RE: **Palisades Subdivision, Replat of Block 4, Lots P-1, Q-1, R-1 # J11-D009**
5209 – 5219 La Bajada Drive NW
Conceptual Grading and Drainage Plan for RePlat PE Stamp:
9/24/2013

Based upon the information provided in your submittal received on 9/24/13, and my subsequent conversations with you and the owner, Chris Sanchez, the above **referenced Conceptual Grading Plan cannot be approved for Platting action**. The extreme grade differential on these lots creates significant concern for the buildability of the proposed lots, as well as the stability of existing, adjacent structures.

DRAINAGE REPORT &
BASIN MAP

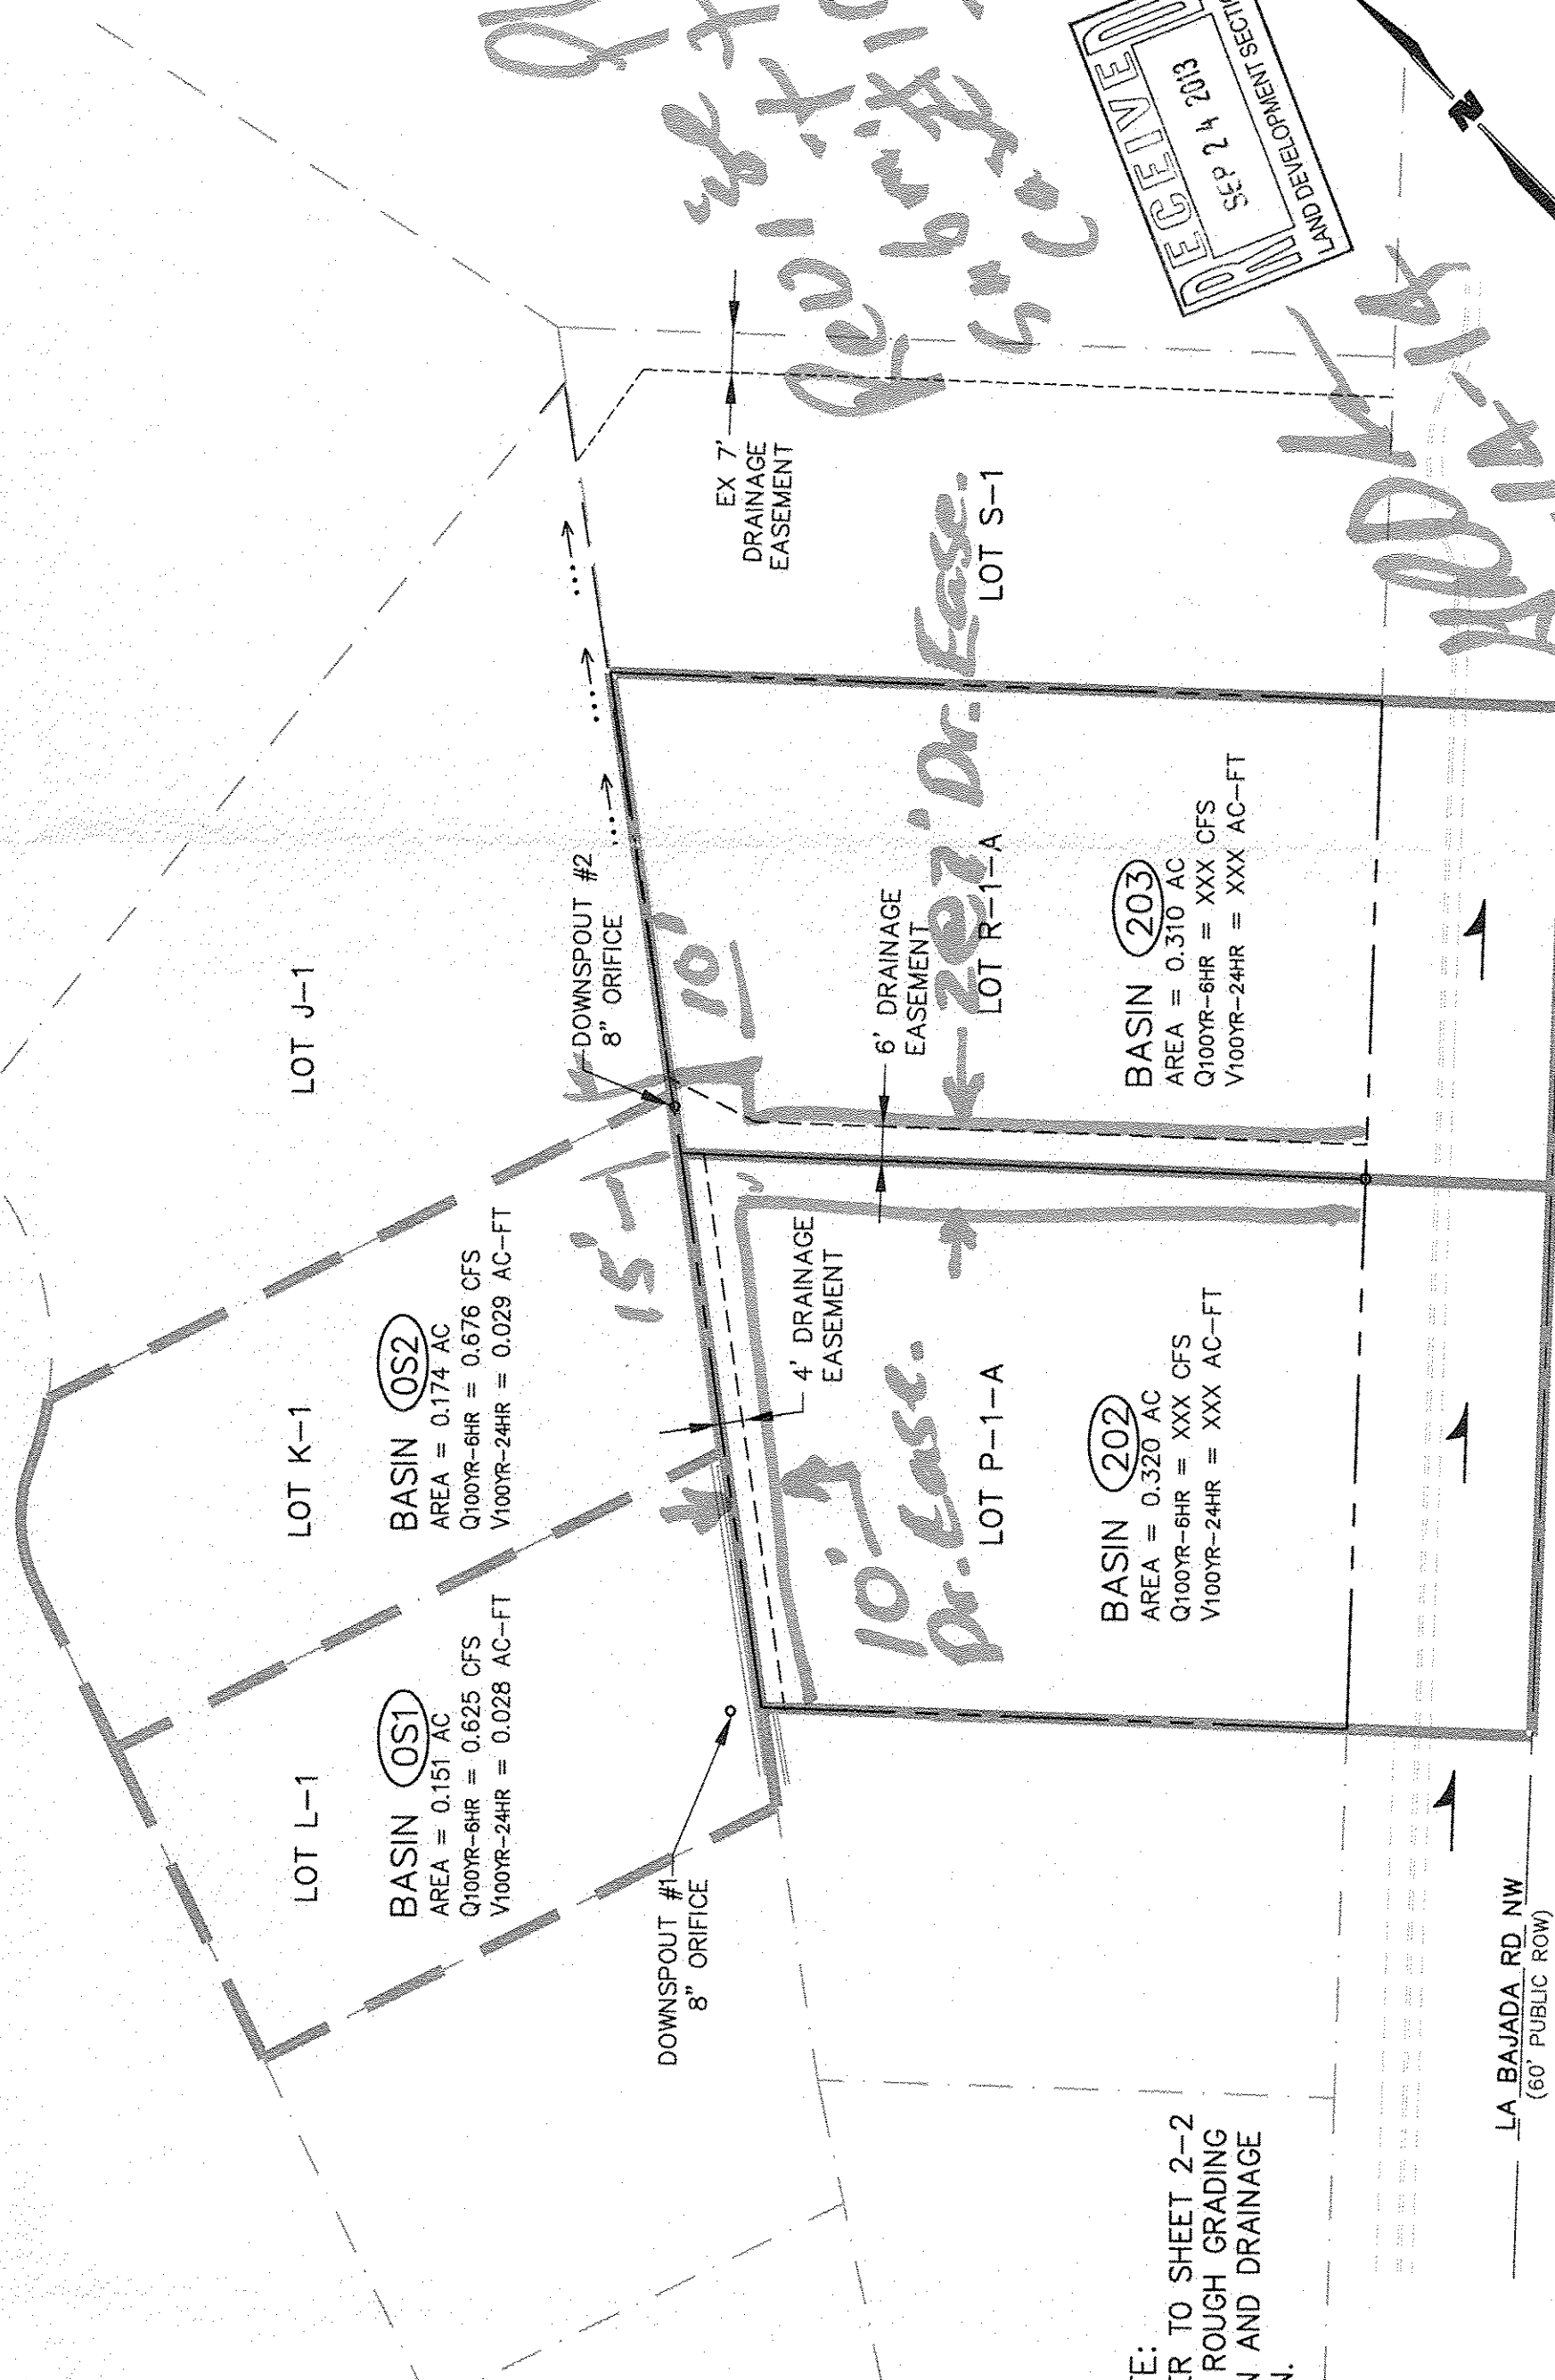
1. The proposed drainage easements must be revised to convey upstream flows through the new lots, SE to La Bajada Street R/W, without crossing the property line to the adjacent lot.
2. Mr. Sanchez indicated to me that he does not intend to do site grading and retaining wall construction for the platted area. Hence, the drainage concept for the proposed lots needs to demonstrate that the new lots will be buildable, individually.
3. The existing survey does not provide offsite grades on the west and south edges of the site, preventing review of impacts on adjacent sites and structures. Per the DPM, this plan should provide offsite grades for 25' beyond the property lines.
4. The drainage concept must also recognize zoning restrictions on maximum wall heights allowed, and Special Exception criteria applicable with excess heights.

5. A major concern is the feasibility (structural & economic) of constructing the proposed retaining wall at the rear lot line, cutting as much as 10-feet below the foundation of the existing retaining walls at the back of the abutting lots. Related to this concern is the proposed 4' wide drainage easement at the base of that wall, conveying runoff, laterally along the top of a 1:1 slope. Any slope over 3:1 requires erosion protection per the DPM. The light, sandy soil on this site may need to be as flat as 5:1 to avoid erosion without protection. It seems more appropriate to proposed terraced retaining walls, offset from the existing retaining walls, to ensure the stability of those structures.
